Project Name: Level 1 Site Alteration: **FEMA Equipment Installation**  
ID Number: 2012 -643  
Address: 236 Lane Avenue, Portland, ME 04103  
(owned by Saga Communication of New England)  
CBL: 302 A006001  
Applicant: FEMA (Darcy Bingham)  
Planner: Jean Fraser

On February 12, 2013, the Planning Authority approved with conditions a Level I: Site Alteration site plan for the installation of a transmitter module, two generators, and a 6000 gallon fuel tank immediately adjacent the existing radio transmitter building at 236 Lane Avenue. The equipment is associated with a Loan Agreement between FEMA and Saga Communication of New England to provide power for radio transmission during major emergencies.

The approval is based on the application including the May, 2012 FEMA Equipment Loan Agreement with Saga Communication of New England LLC; KBR letter dated January 24, 2013; letter from Saga Communication of New England LLC dated February 6, 2013; and plans G-001, G-101, C-101, C-102, C-103, C-301, S-502 all dated 1.16.2013 and plan S-102 dated 1.22.2013 as submitted by KBR.

Drawing Number:  
**G-101**

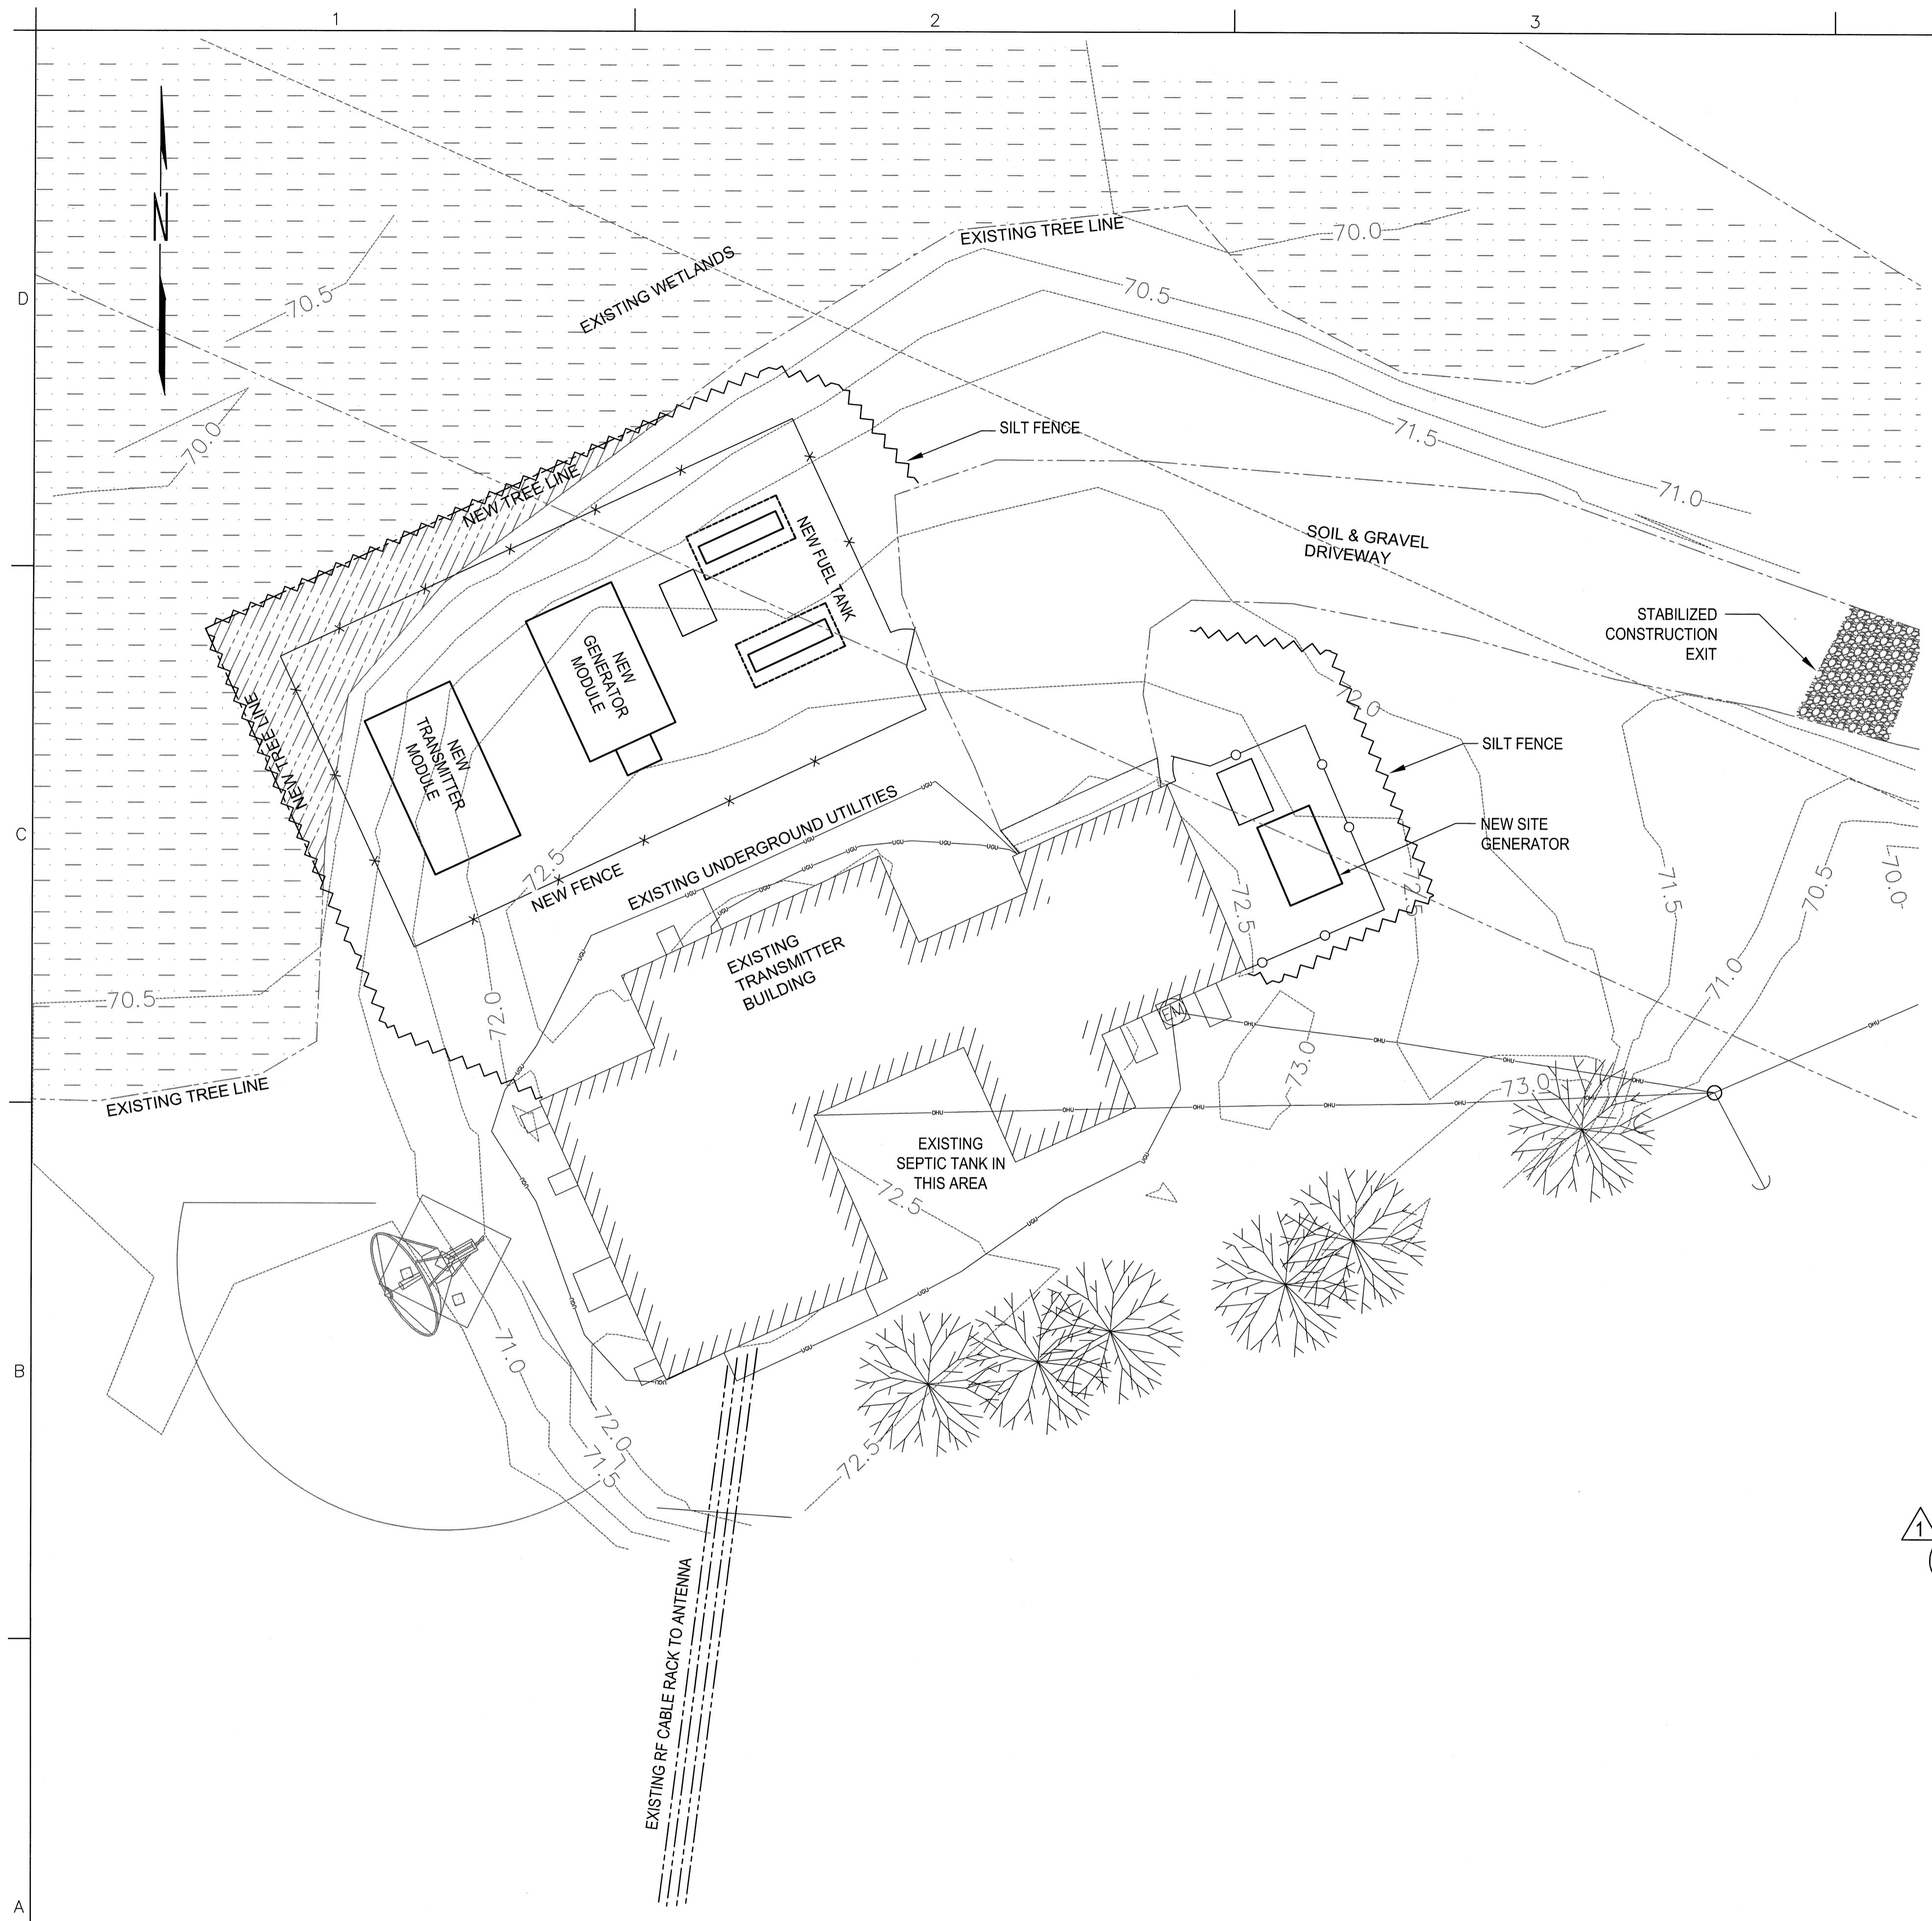
As stated several times, I would prefer not to make a determination until I have ALL the facts. Having the applicant put a zone line on their site plan is a must. I am not sure at this time whether the applicant can use the 30' zone line extension or not. I will consider that allowance. If worse comes to worse, there is a "solution" in the R-3 zone as a conditional use appeal to the ZBA. But I am not telling them to do that yet.

I reviewed the submitted plan showing the R-3 zone line. The line does bisect the project area. There is approximately 20 feet of the project area located currently within the R-3 zone. However, 14-51 allows a 30 foot expansion of the less restricted zone (B-4) into the most restricted zone (R-3). It appears that there is approximately 178 foot of road frontage along Lane Avenue, and therefore the applicant has the ability to adjust the B-4 zone line into the R-3 zone. We should get a revised plan showing a dotted line of the 30 foot extension for our records. There is no special steps for the applicant to take regarding the zone extension. Such an extension is allowed by Ordinance if the conditions are met. I believe the conditions are being met.

The project still must not exceed the maximum noise allowances of the B-4 zone. The applicant should submit projected dBAs accounting for required landscaping.
